SILVERADO RANCH FILING NO. 2

IN THE NORTHEAST QUARTER OF SECTION 16, T15S, R63W, 6th P.M.
EL PASO COUNTY, COLORADO

V1_Final Plat Drawings.pdf Markup Summary

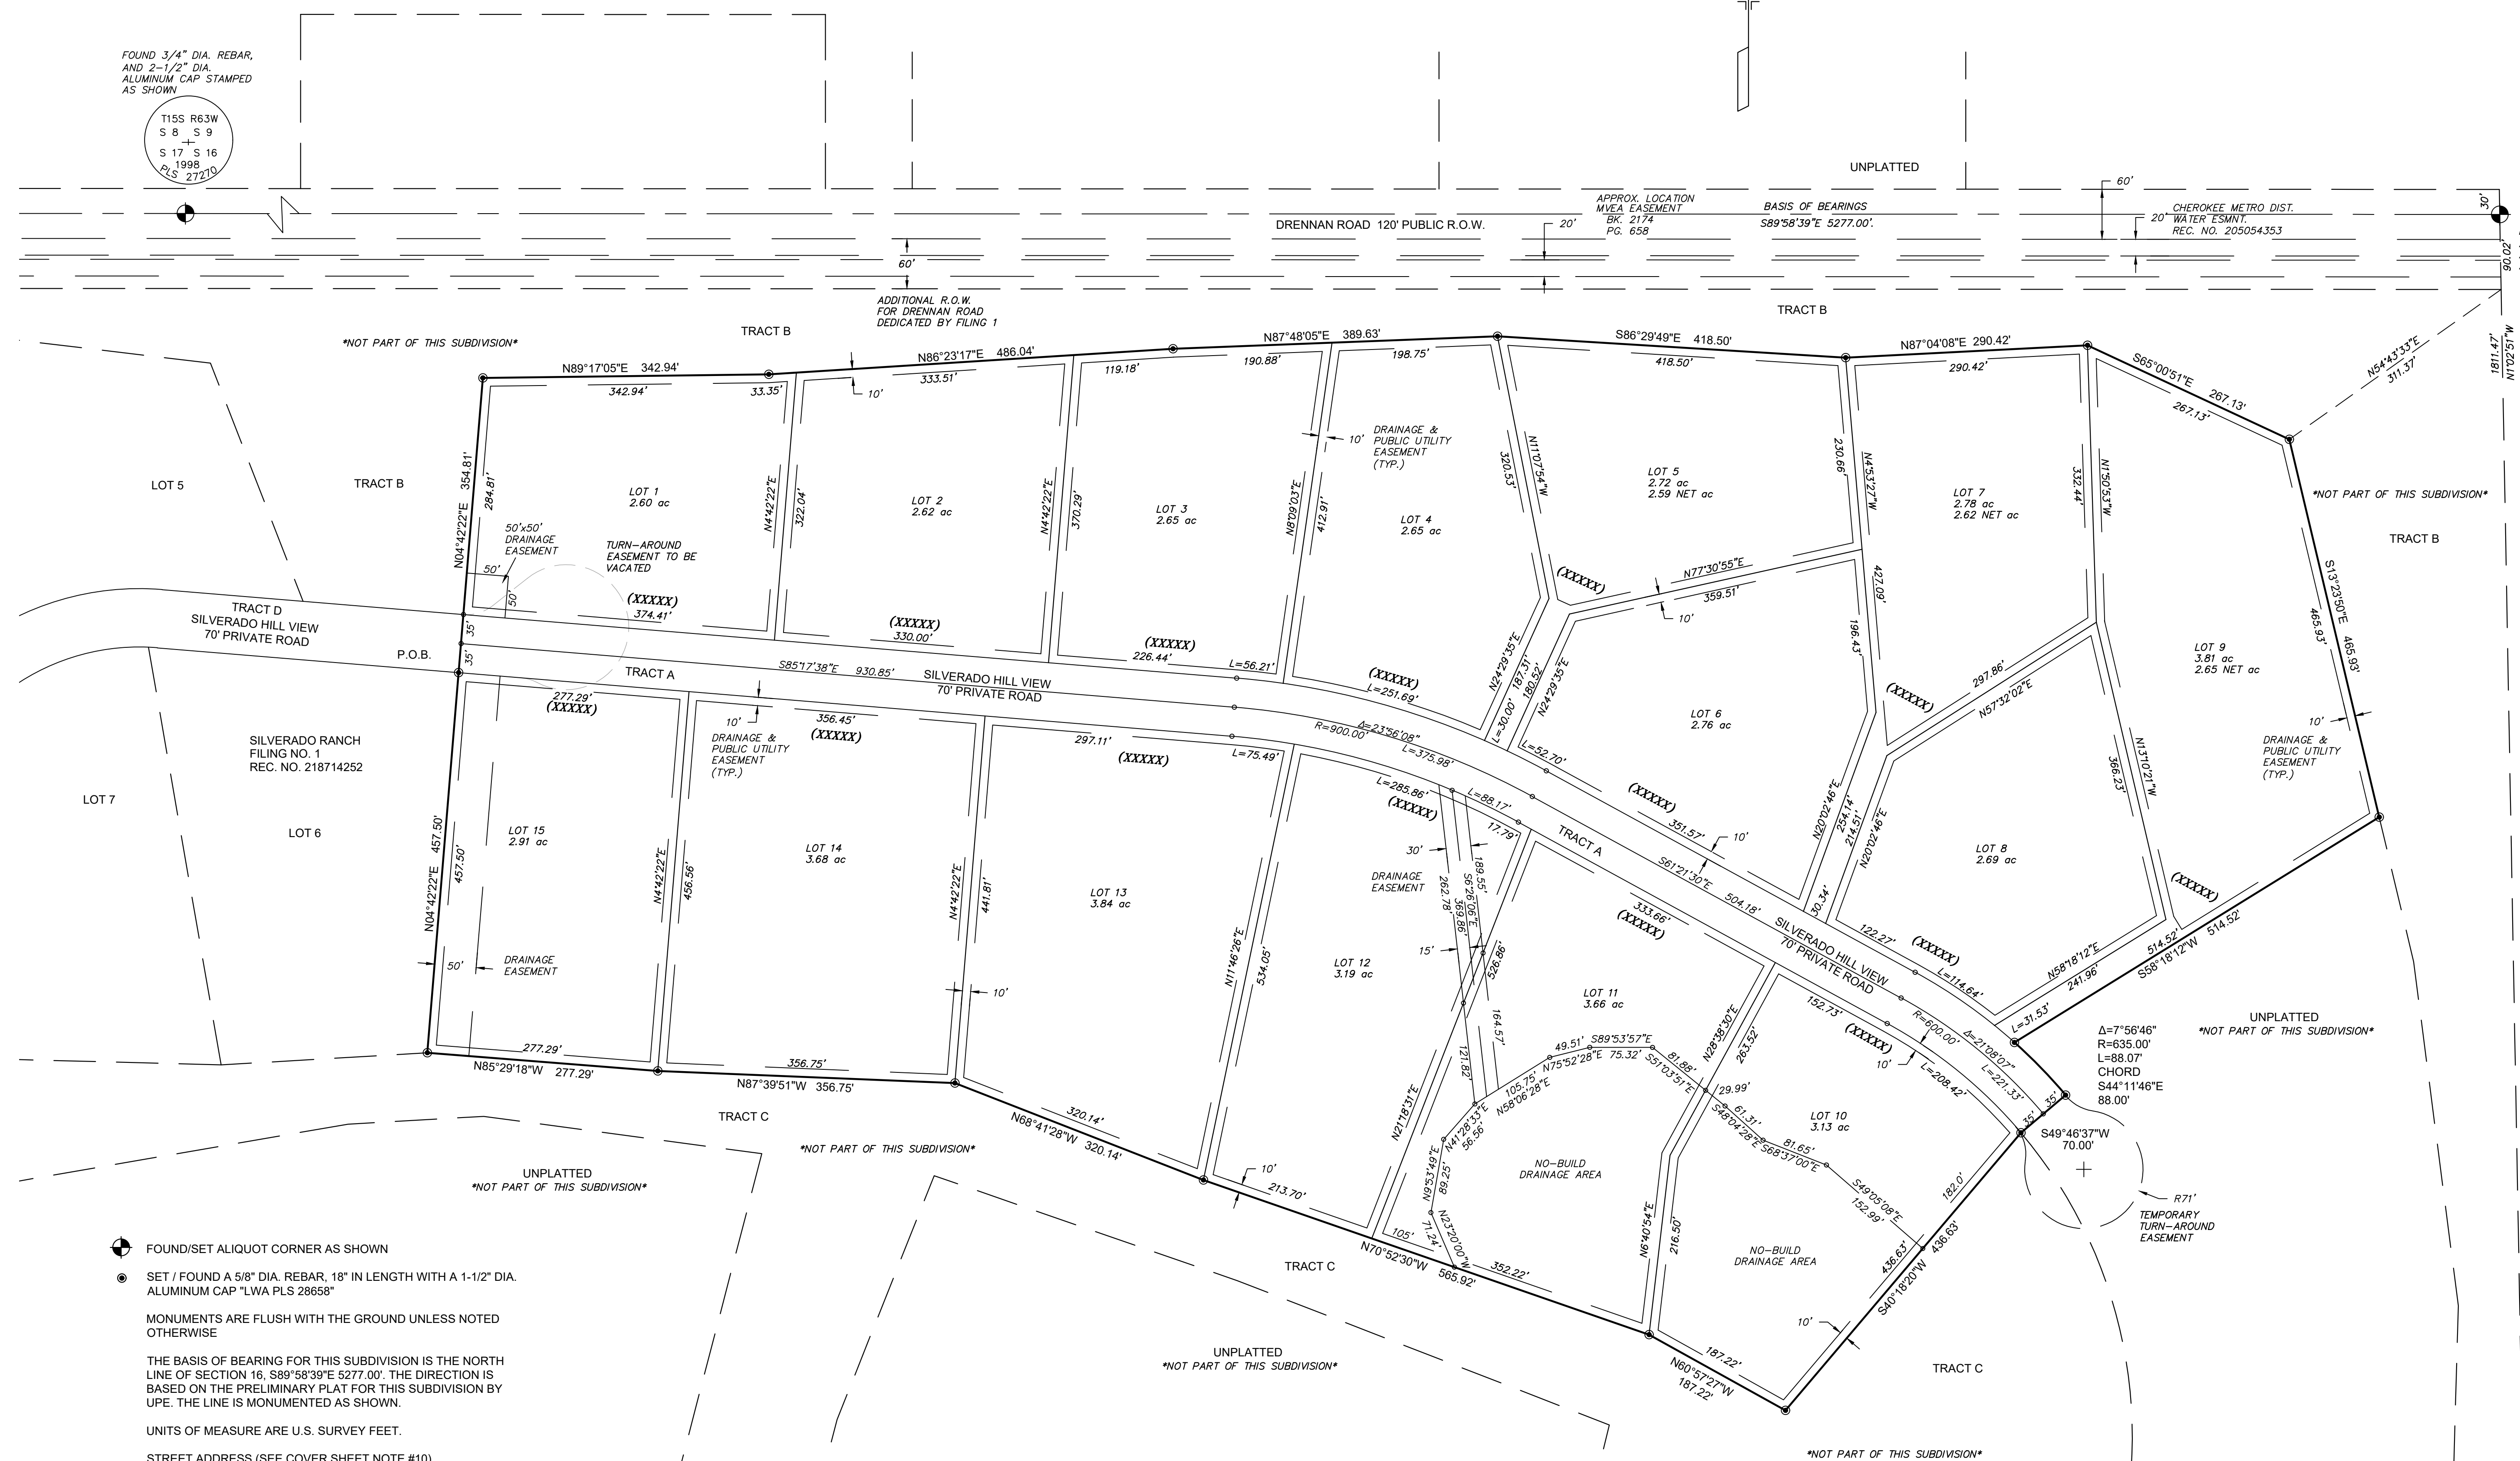
Linetypes are all very similar. Please try and have some bigger differences between ROW, easements, centerline, etc

Label existing row

Shown as Silverado Hill Loop on the previous plat (Phase 1)

Rename to Silverado Hill Loop. As shown on Phase 1

Rename to Silverado Hill Loop. As shown on Phase 1
